CHESHIRE WEST AND CHESTER COUNCIL

Frodsham Solar DCO - EN010153

Cheshire West and Chester Council's comments on Deadline 4 documents

Submission for Deadline 5

Figure Title **Public Rights of Way - Closures and Diversions - Section 1: Ellesmere Port and Neston RB40 / Frodsham RB106 / NCN5**

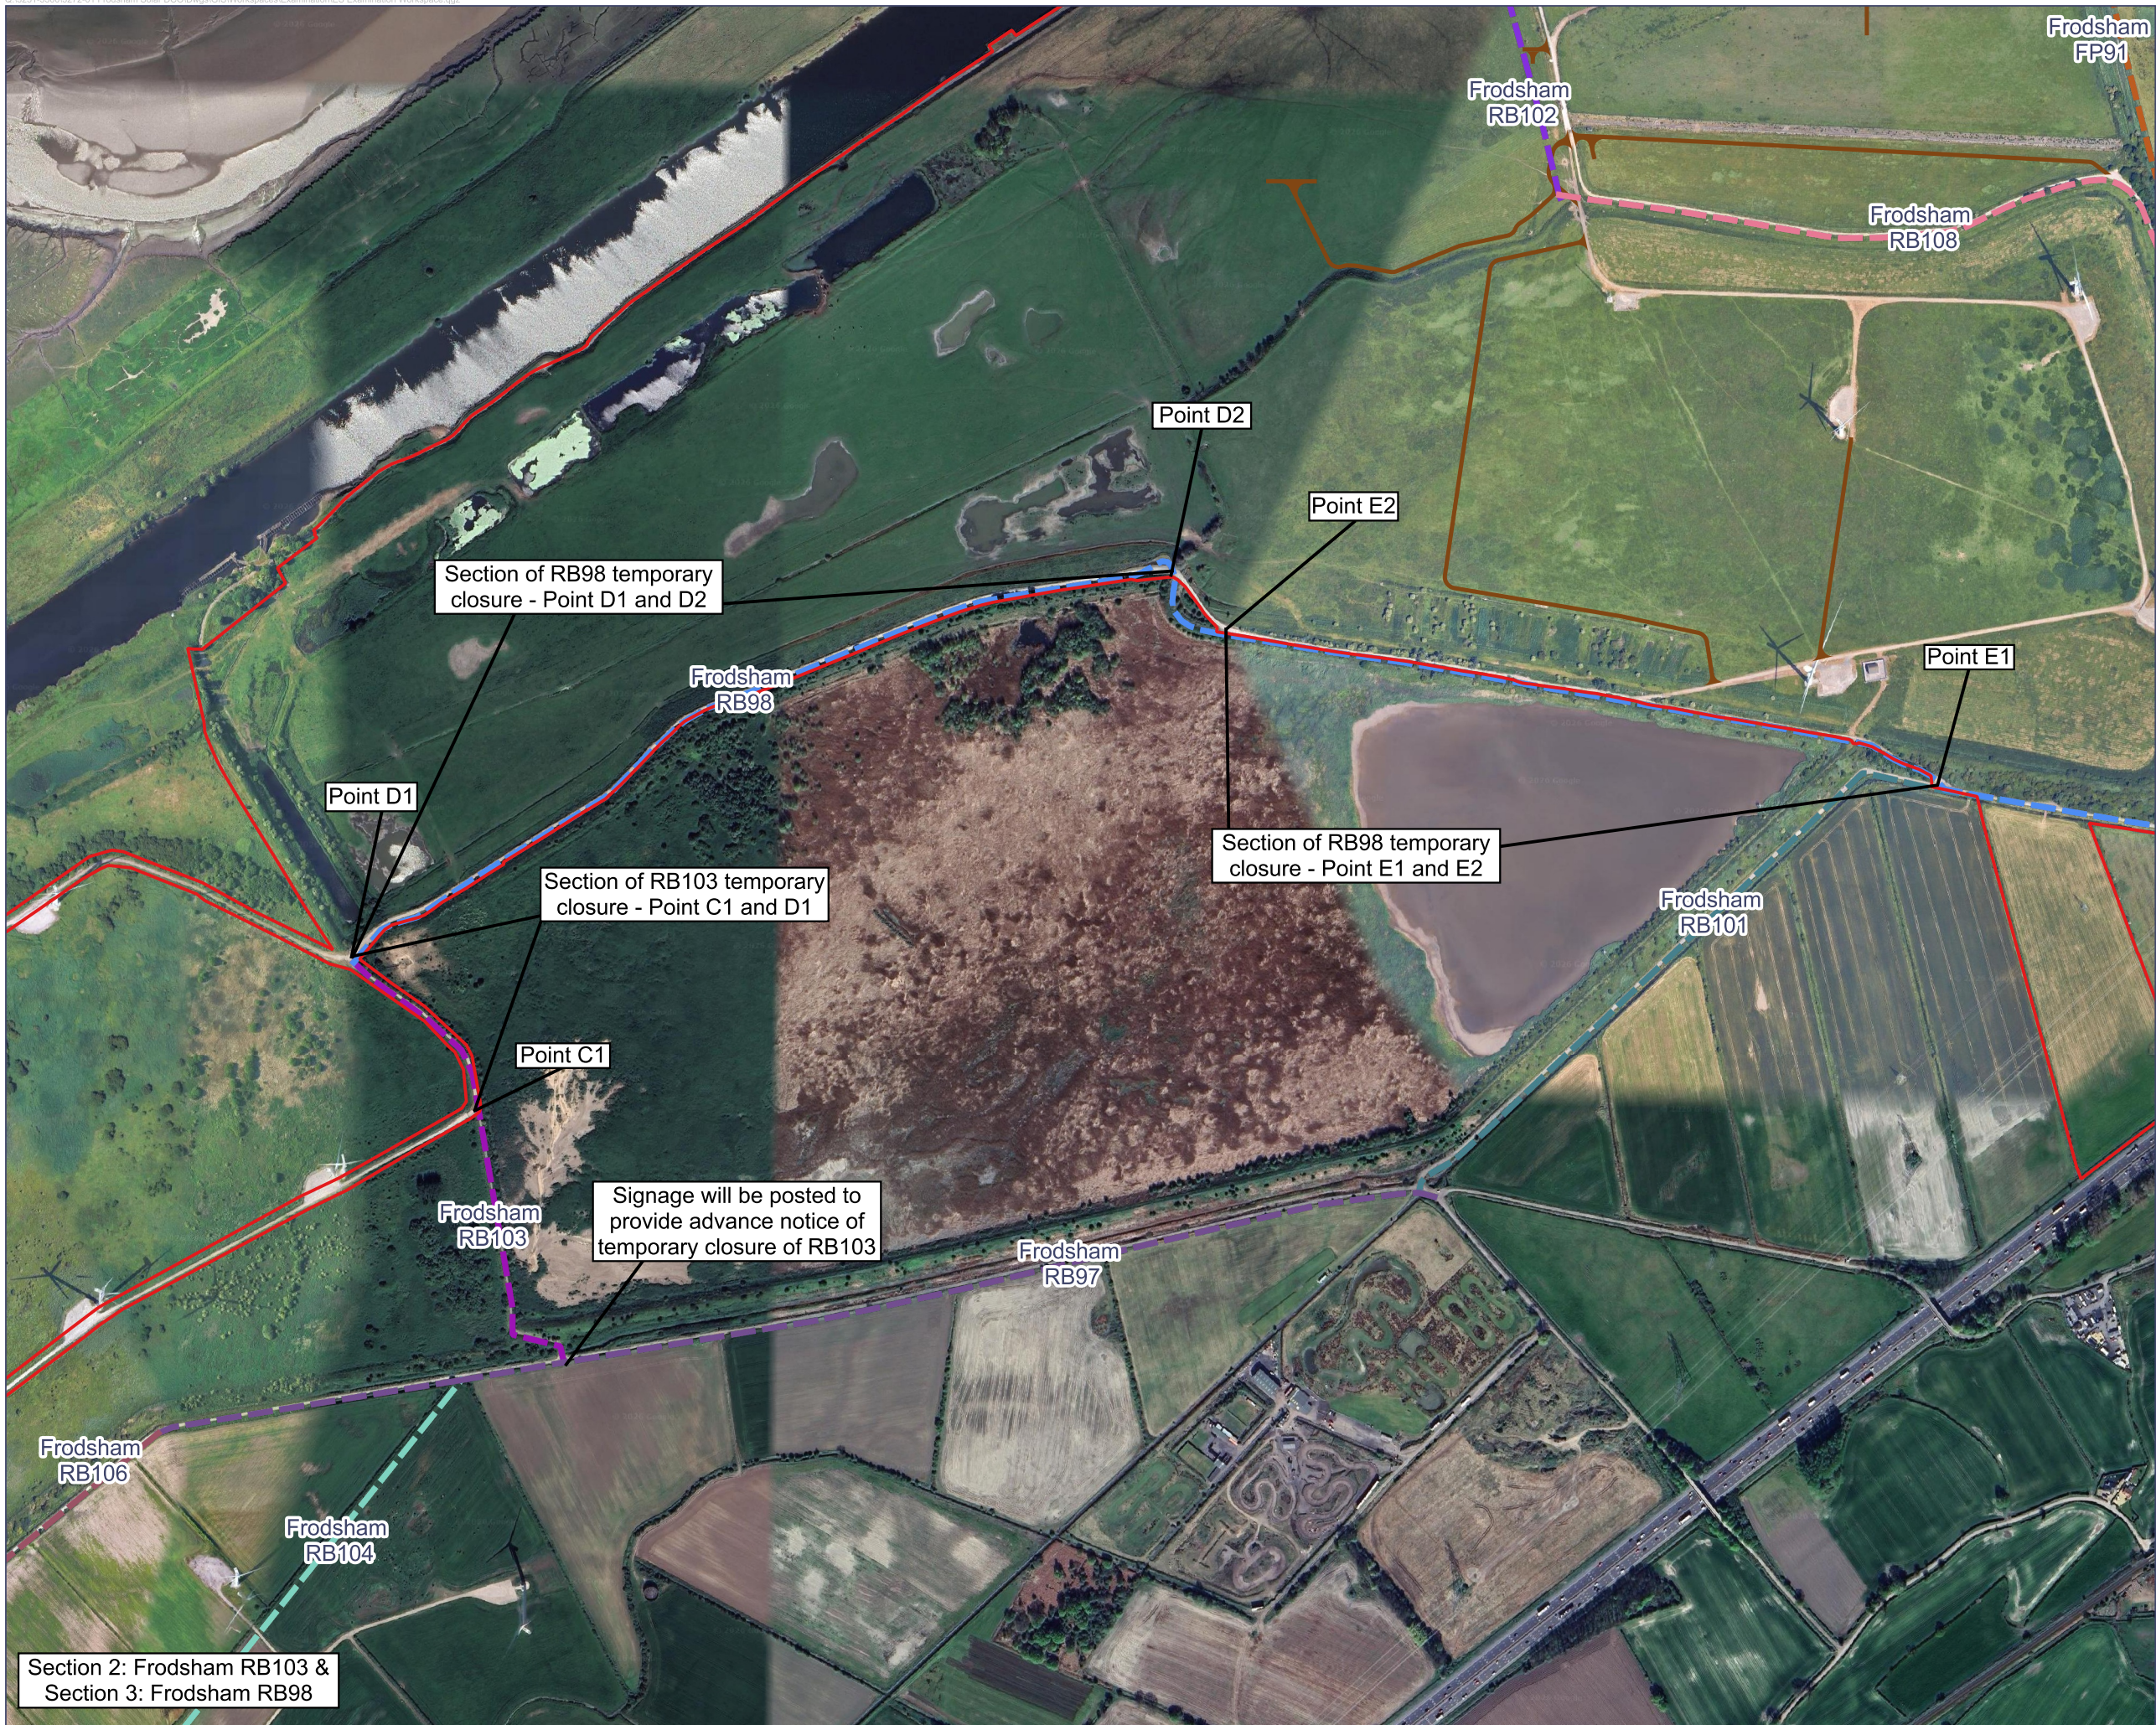
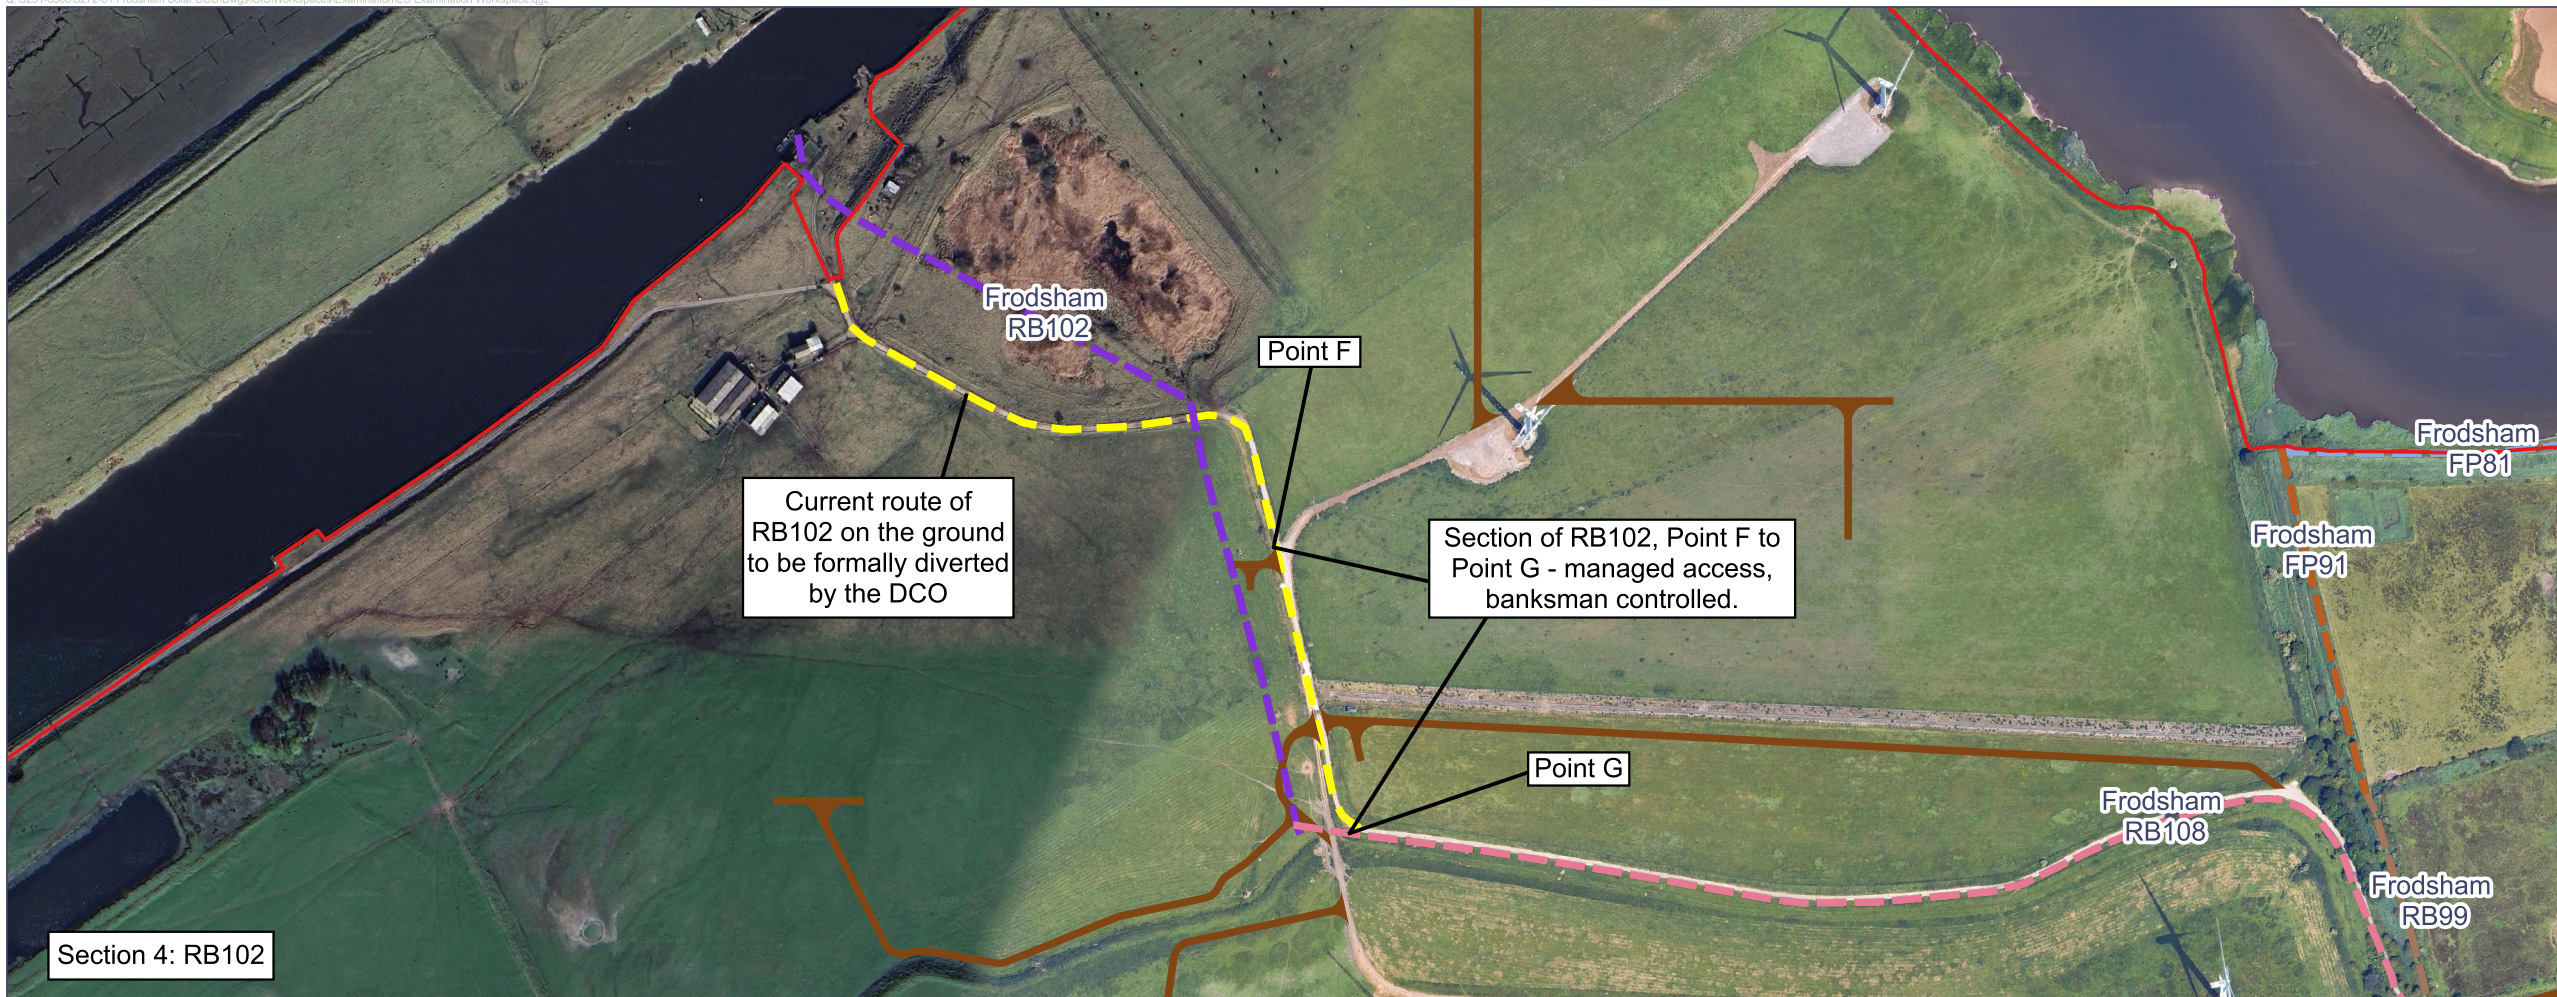
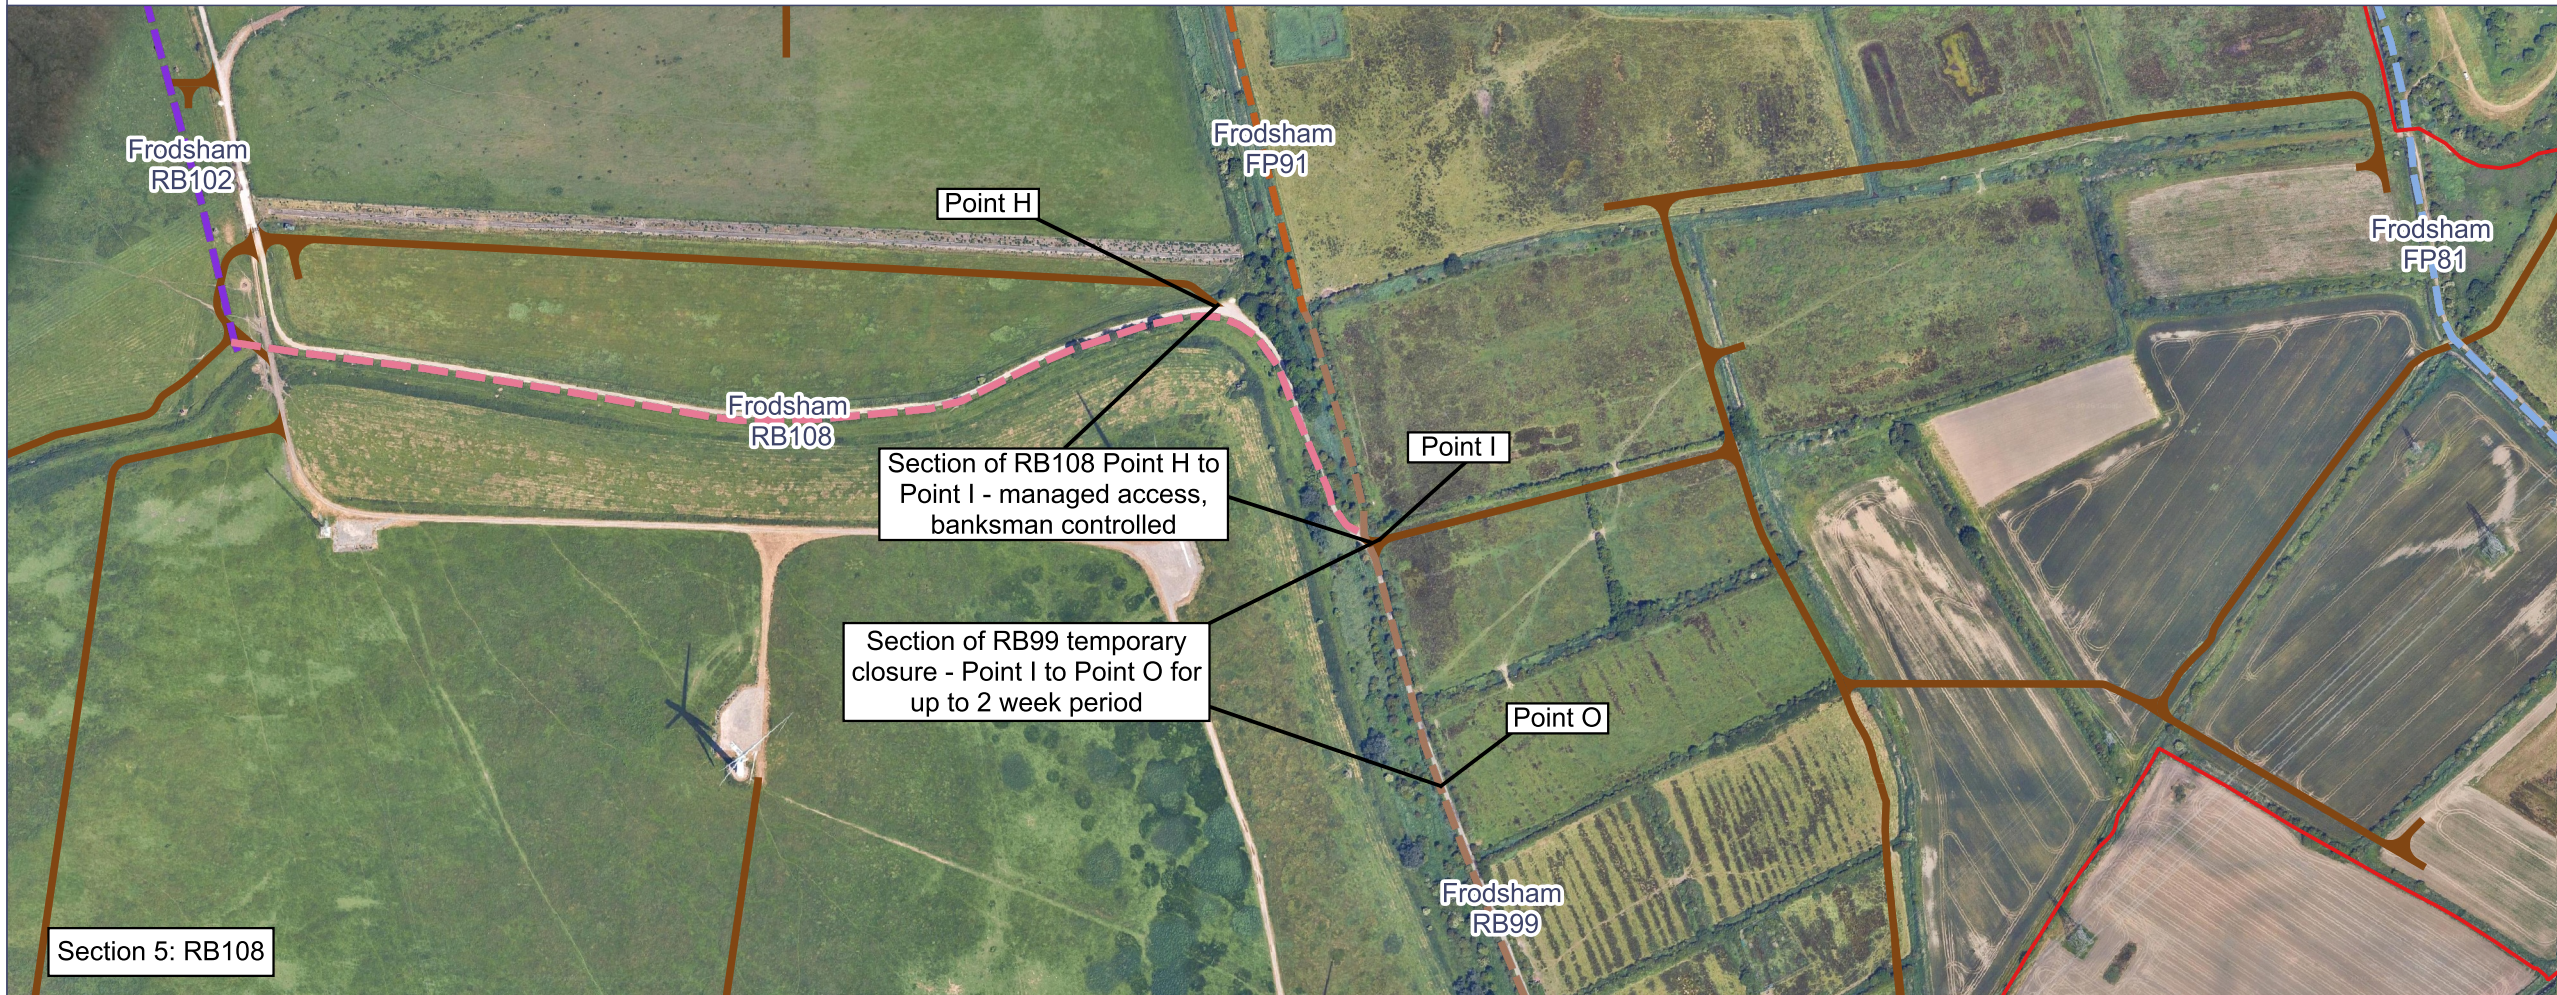
Ref	Document Para number	Document summary point	CWCC comments	Status
REP4-034 7.9 Outline Public Rights of Way Management Plan - P04				
D5.1.17.1		General	CWCC have requested the Applicant to include the public rights of way figures (Figures 2-1 to 2-5) provided in REP4-055 in response to the ISH Action Point 15 within the oPRoWMP and/or oCTMP.	
D5.1.17.2			Any further comments to be provided at Deadline 6 .
